POST RESPONSE TO SUBMISSIONS REPORT

ALEX AVENUE PUBLIC SCHOOL_SSD_9368

This supplementary Response to Submissions (RtS) Report has been prepared to respond to further submissions received in relation to SSD 19_9368 for 'Alex Avenue Public School'.

180645 AA-AR-1100 E.2

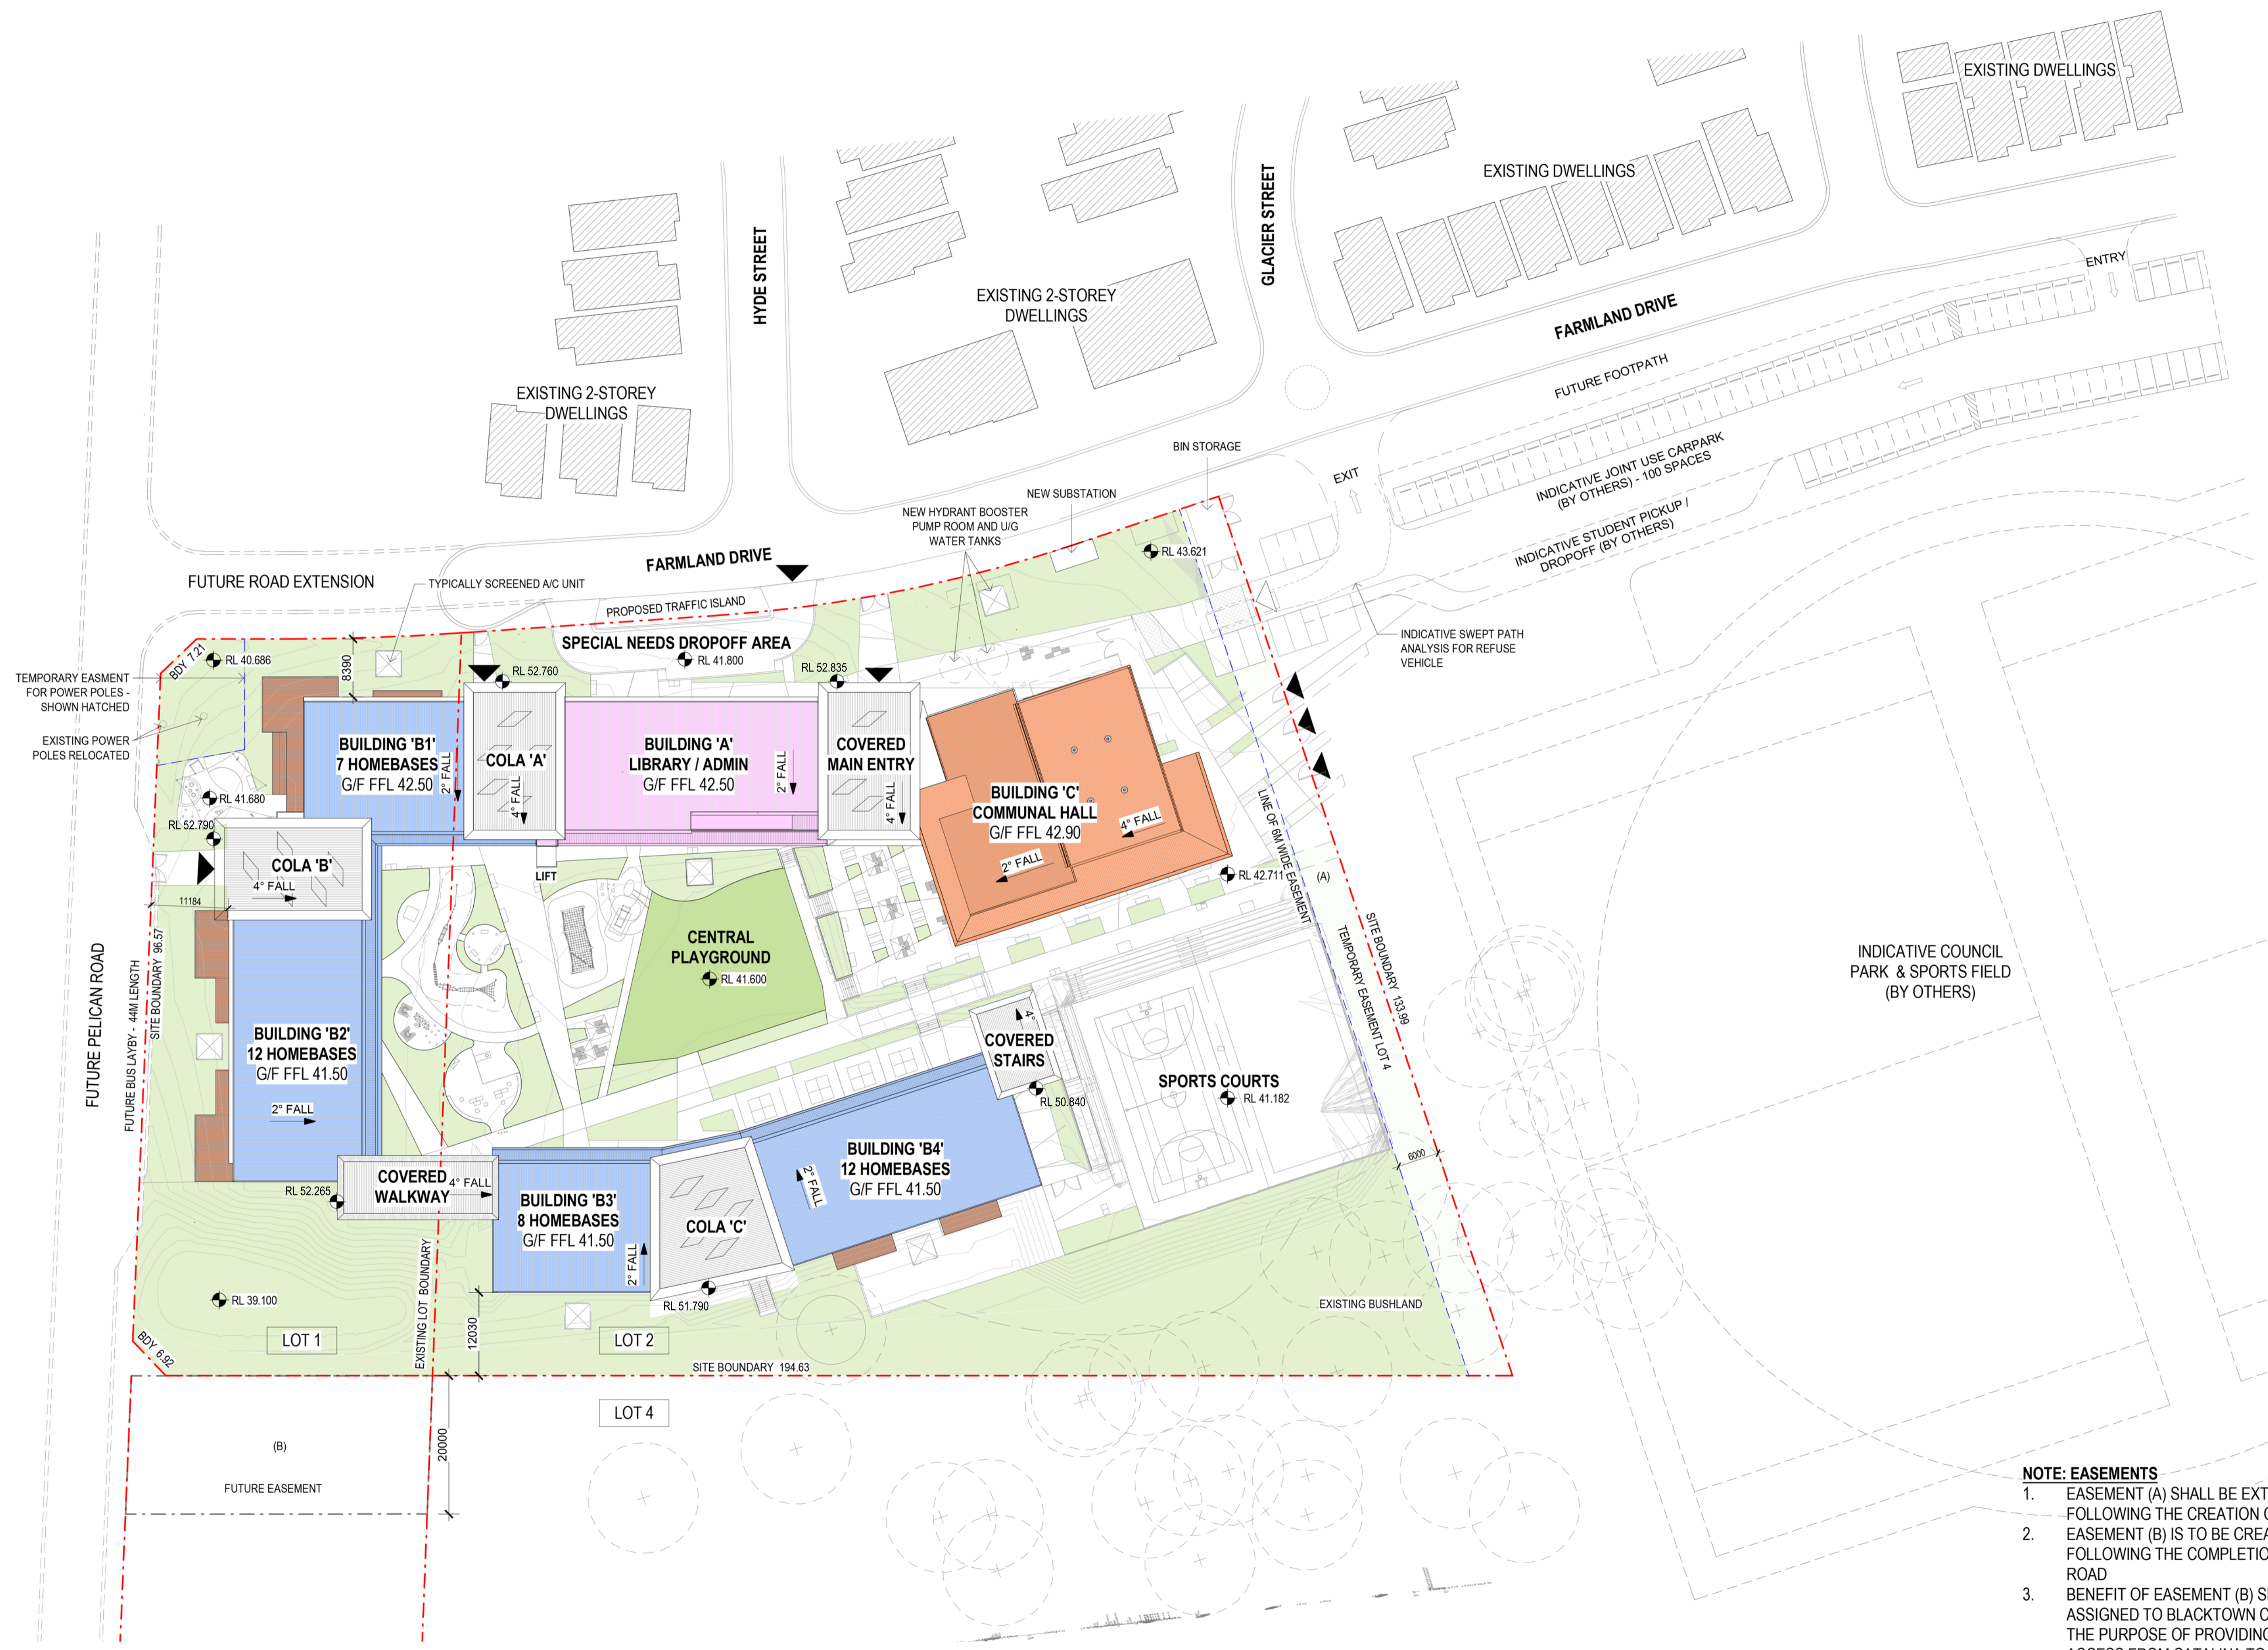
31.	As the primary entry to the school, the drop off zone, substation, bin storage areas, retaining walls and basketball courts cannot function properly in the easement, and the current layout is not therefore viable. This is still not addressed: Bin storage area are still planned in the easement. Interface of school and the playing fields does not work - there is currently a 4-6 m height variance proposed at the south eastern corner of the new School. This will preclude co-use arrangements proposed between the school and the playing fields and result in poor light, circulation and large retaining walls at the boundary of the school. Drainage is also a problem here - see comment below.	The easement will remain unencumbered whilst Easement A is in place. The waste bins will be managed so the bins remain within the school site and can still be accessed from the joint use carpark which will be managed by the School. The southern edge of the school follows the lay of the land and is sympathetic to the future development of Lot 4.

1 FARMLAND DRIVE STREETSCAPE ELEVATION
1:300

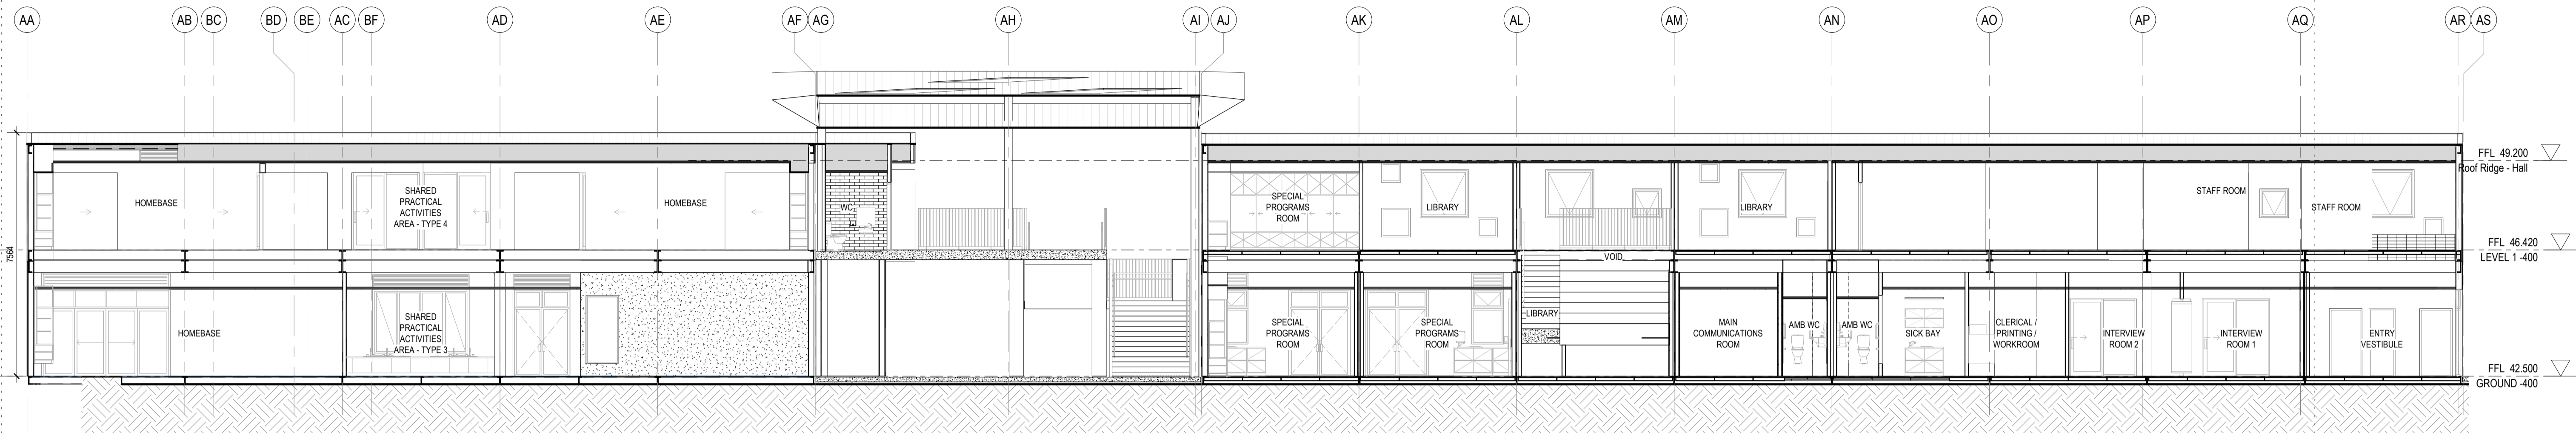
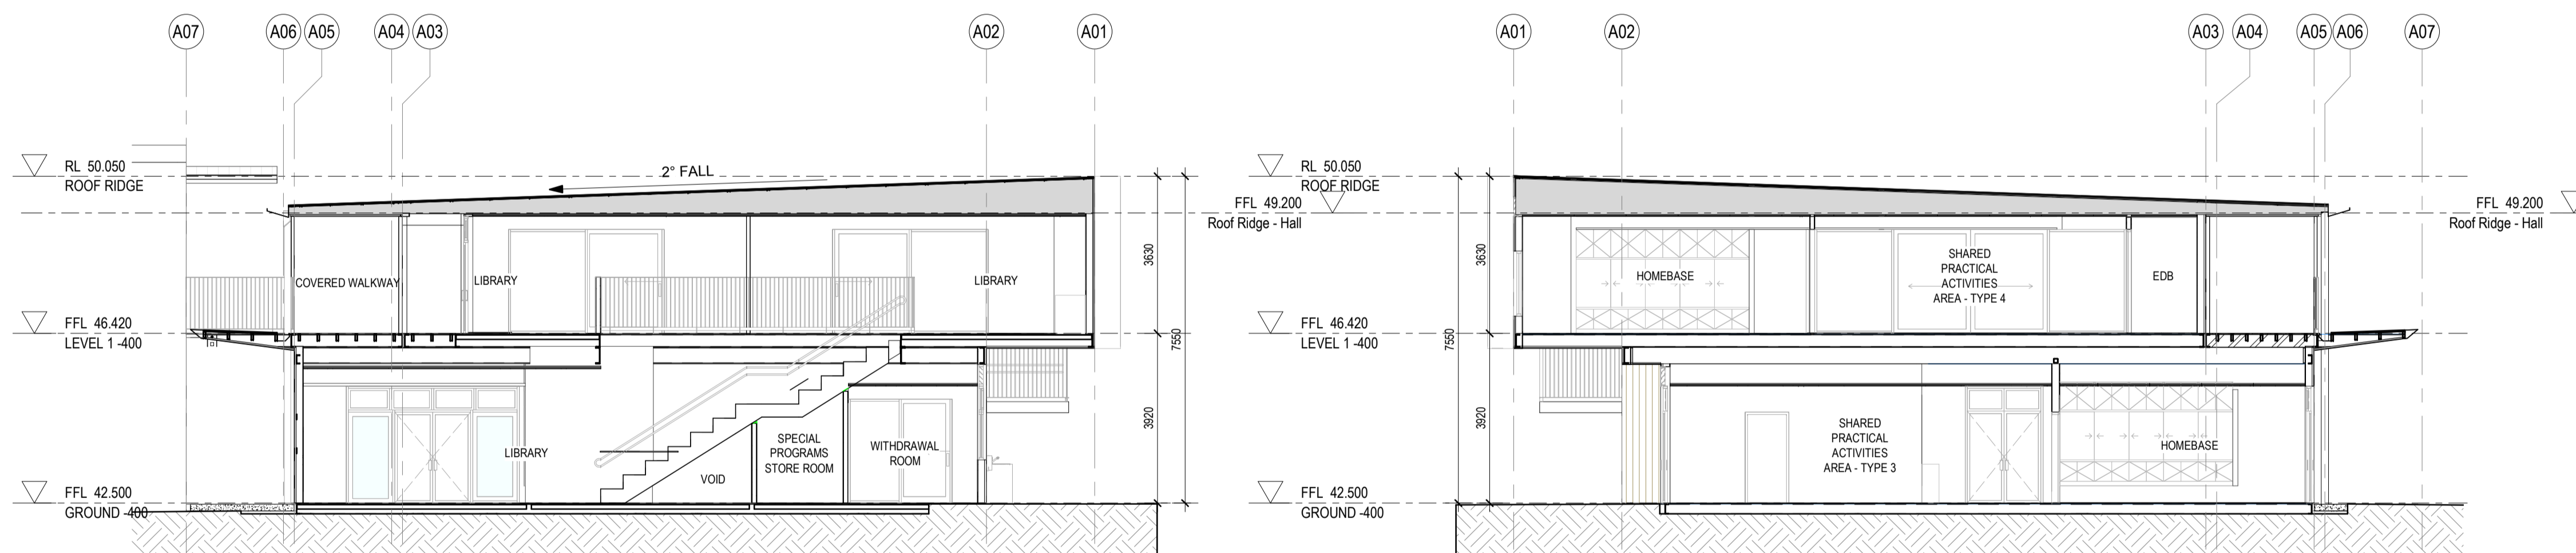
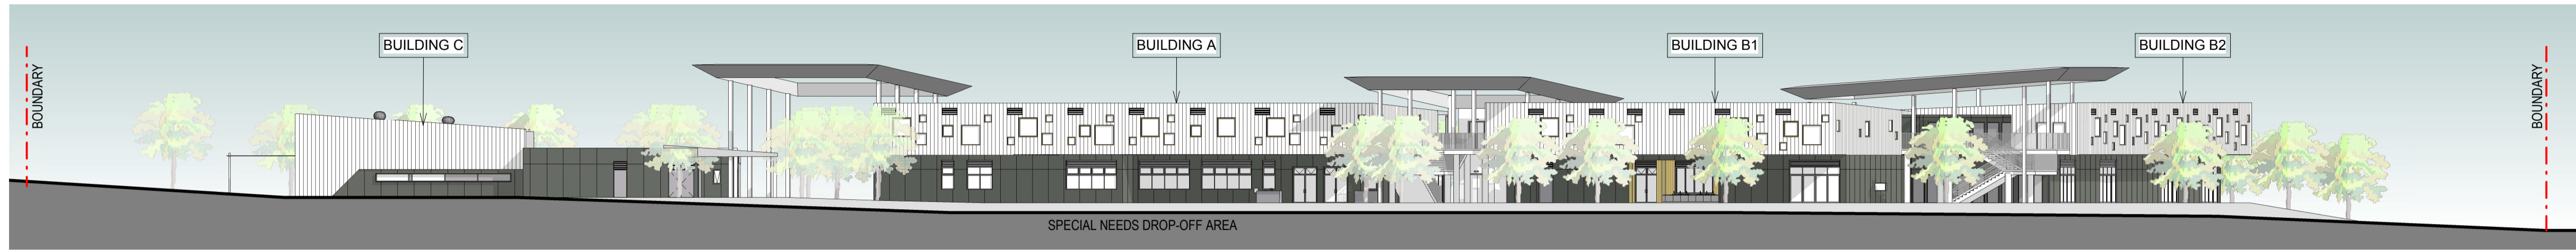
Government Architects NSW:			
3. Design Feedback	The relationship between the hall and Farmland Drive is a large blank façade with only a couple of small door openings. This façade should be further articulated to create an engaging, welcoming interface with the street.	A letter from Group GSA has been prepared to address concerns with the blank façade and is submitted at Appendix A. The letter provides a series of artists impressions taken along Farmland Drive to aid in the understanding of the scale and materiality of the site and surroundings. The scale and massing of the hall and school entry are developed with a conscious awareness of the scale of the surrounding two storey-built form,	Appendix A

Issue	Comment	DoE Response	Reference
		as well as a consideration for the environmental context of the site. The articulation of the entry COLA allows for a strong visual identity for the school, whilst maximising visibility to the public domain. The public domain in the front of the school is articulated in the landscape design and is arranged to accommodate the functional requirements surrounding the main entry. The facade of the hall facing Farmland Drive is small in scale and is not considered a 'large blank facade'. The facade is broken up with materiality. The Farmland Drive curtilage to the Hall houses the site substation and pump room for authority access. The location of these services is limited due to the current extent of Farmland Drive and minimal street frontage.
